Town & Country Planning (Control of Advertisement) (England) Regulations 2007 (as amended)

Application No: CM/61/21/A
Site Address: Bairds Farm Shop, Garden Centre Crookthorn Lane Climpling BN17 5SN
Description of works: Installation of 1 x externally illuminated fascia sign, 2 x non-illuminated fascia signs, 1 x internally illuminated menu drive through sign to south boundary, 2 x A boards and 2 x roadside flags.

Thank you for your internet representation made on 13th December 2021 which has been recorded as an objection with the comments as follows:

Location Plan
Scale: 1:1250

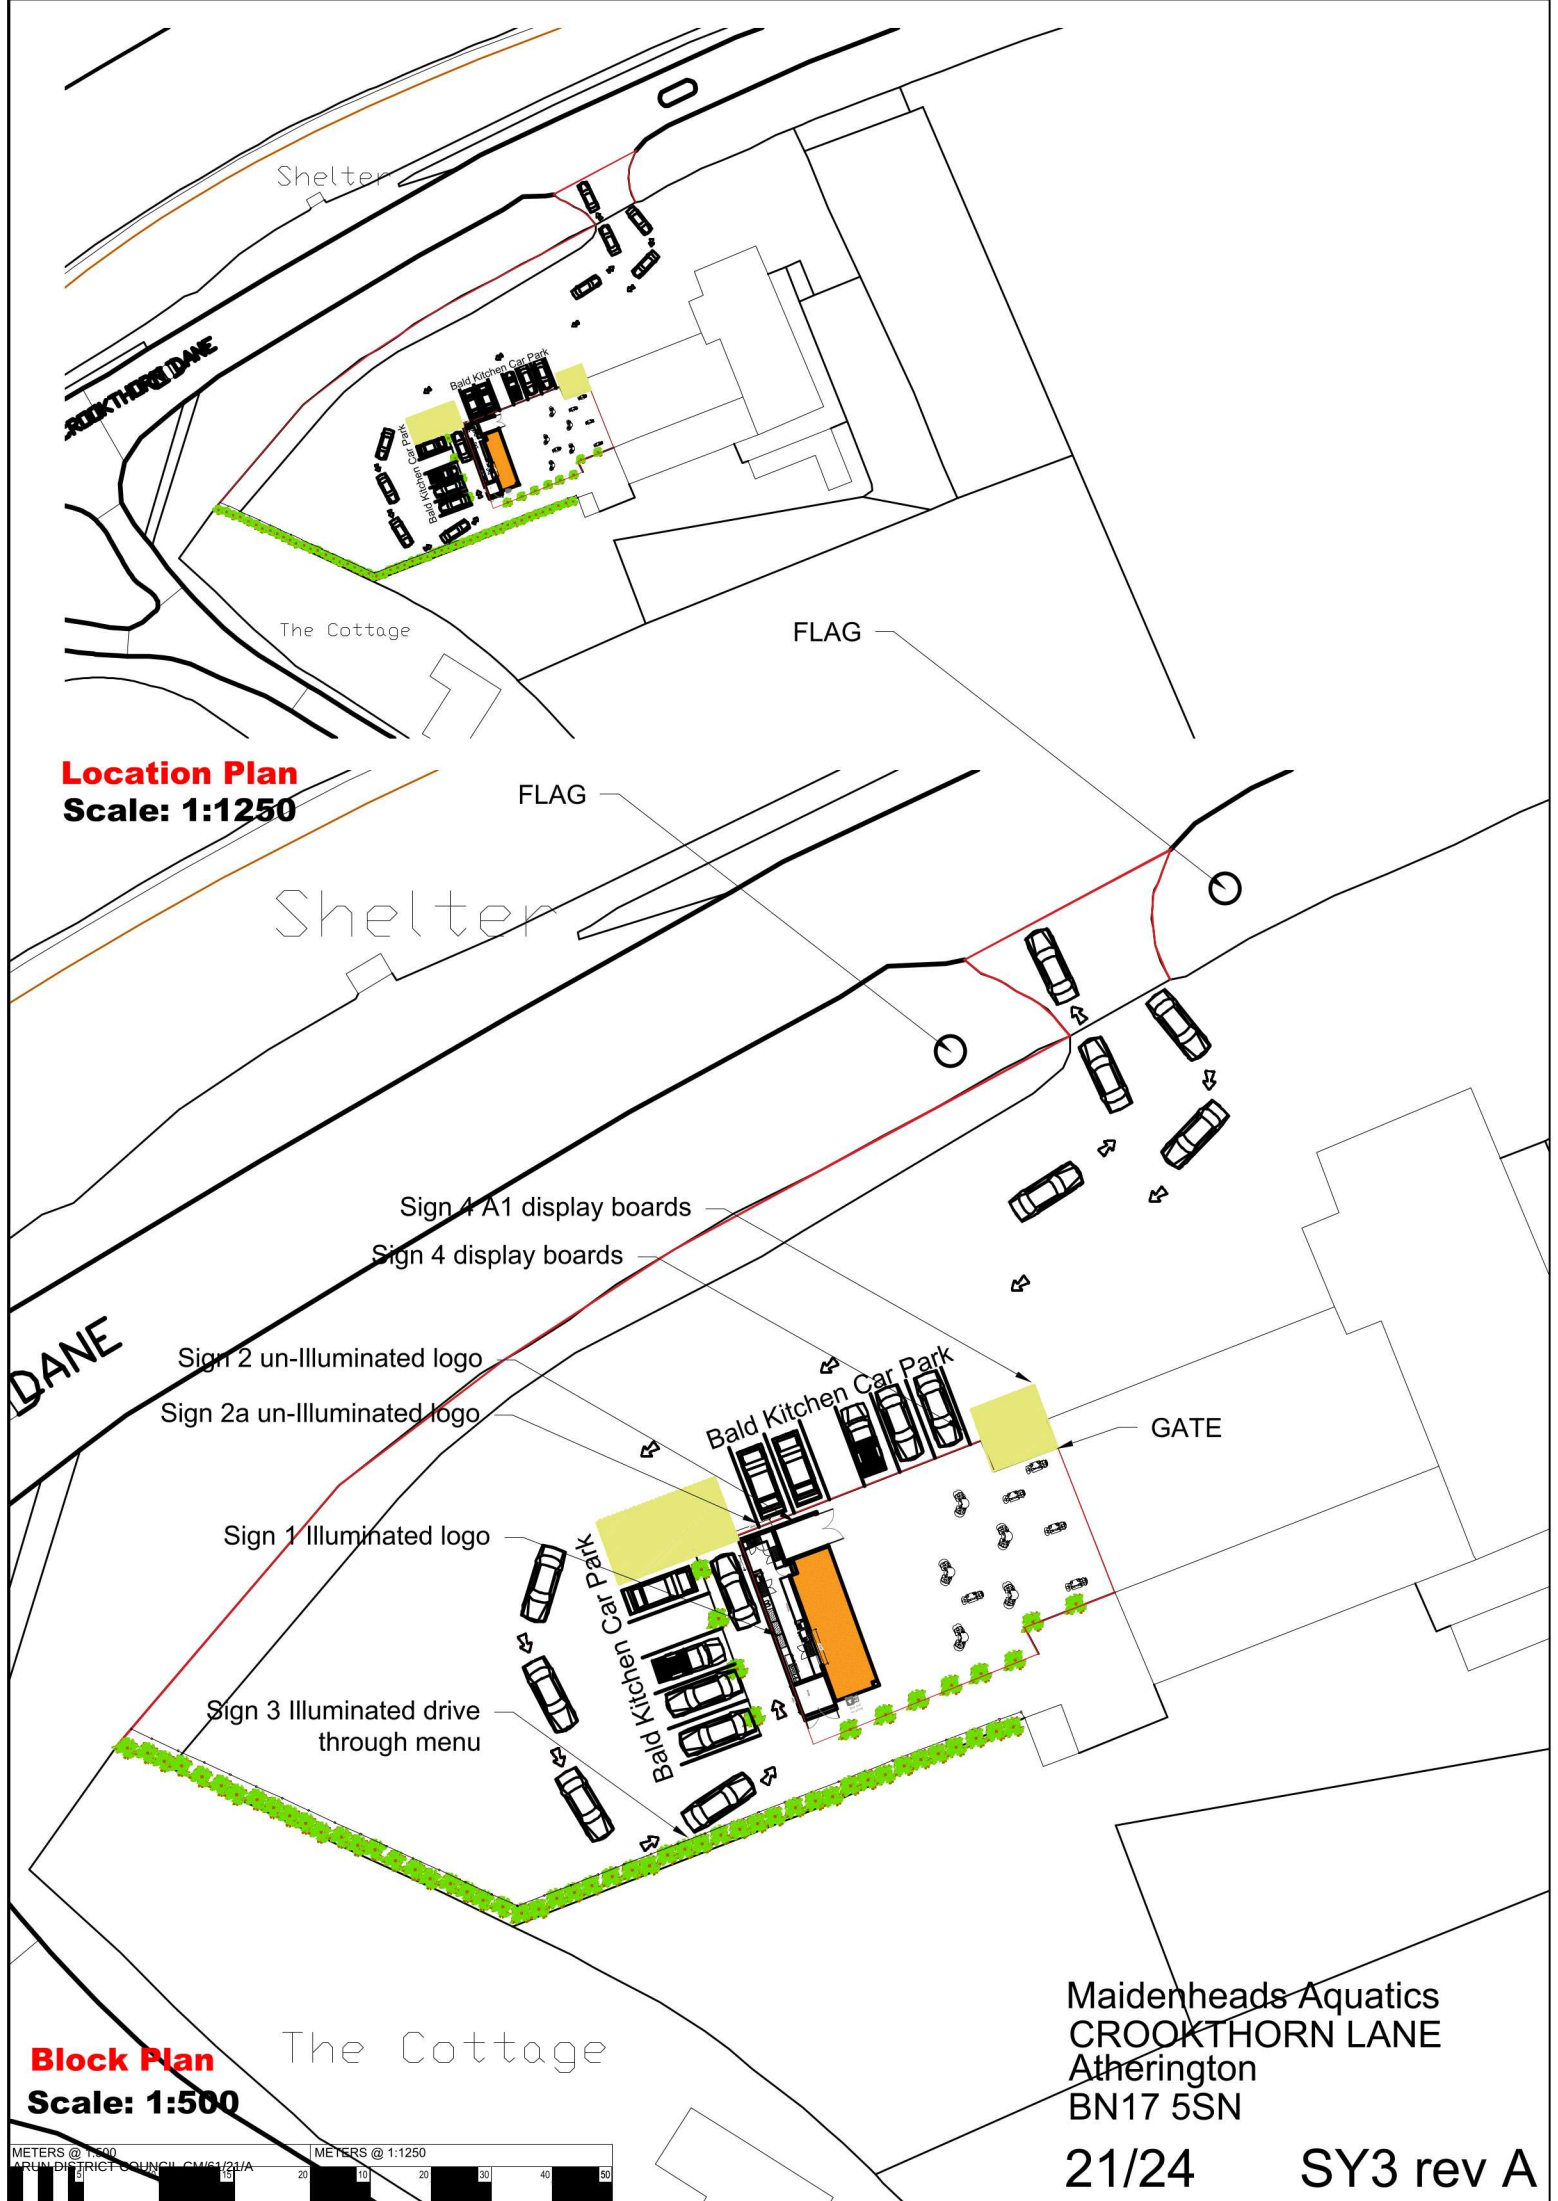
The planted screening shown in the location plan is not in place. The current lighting and advertising therefore directly affect the ineffectively screened grade II listed cottage. Further lighting and signage will impact the setting of the nearby Grade II listed cottage significantly.

Proposed Logo - Sign 1 Luminated Sign
Scale: 1:20

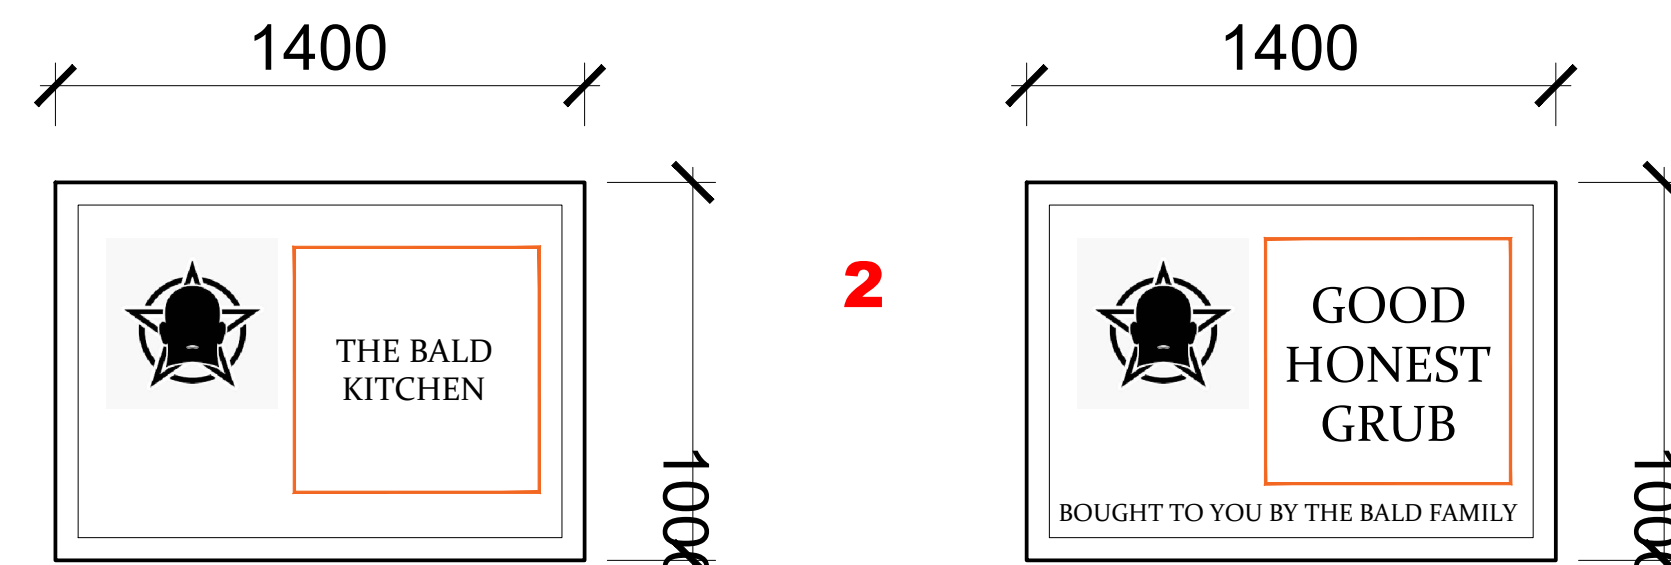
Clympling Parish Council strongly objects to this application on the basis that a proposal for illuminated fascia signs and further non-illuminated signs at this site is inappropriate and totally out of keeping with the character of the area and will intrude on a rural area.

The dark skies in this rural area are being destroyed and the illuminated signs will have an adverse effect on wildlife and are inappropriate to their setting

Flag to go road side
Scale: 1:20

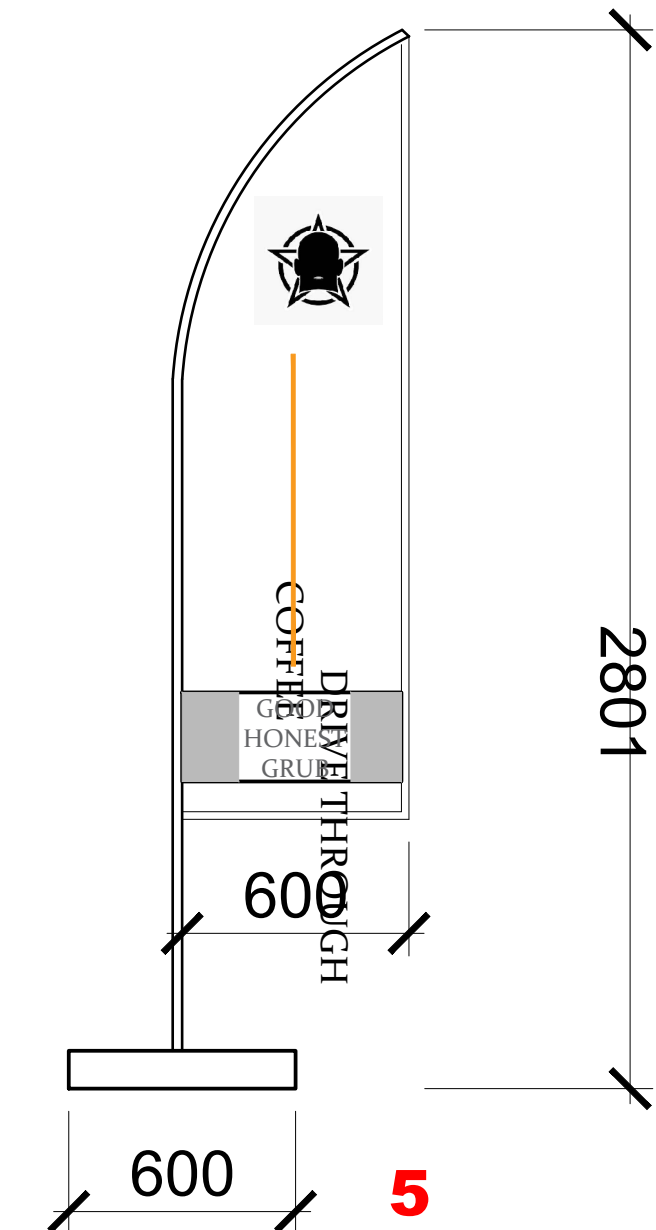
The proposed lighting and roadside flags would be a distraction to drivers on the A259 that will only get busier.
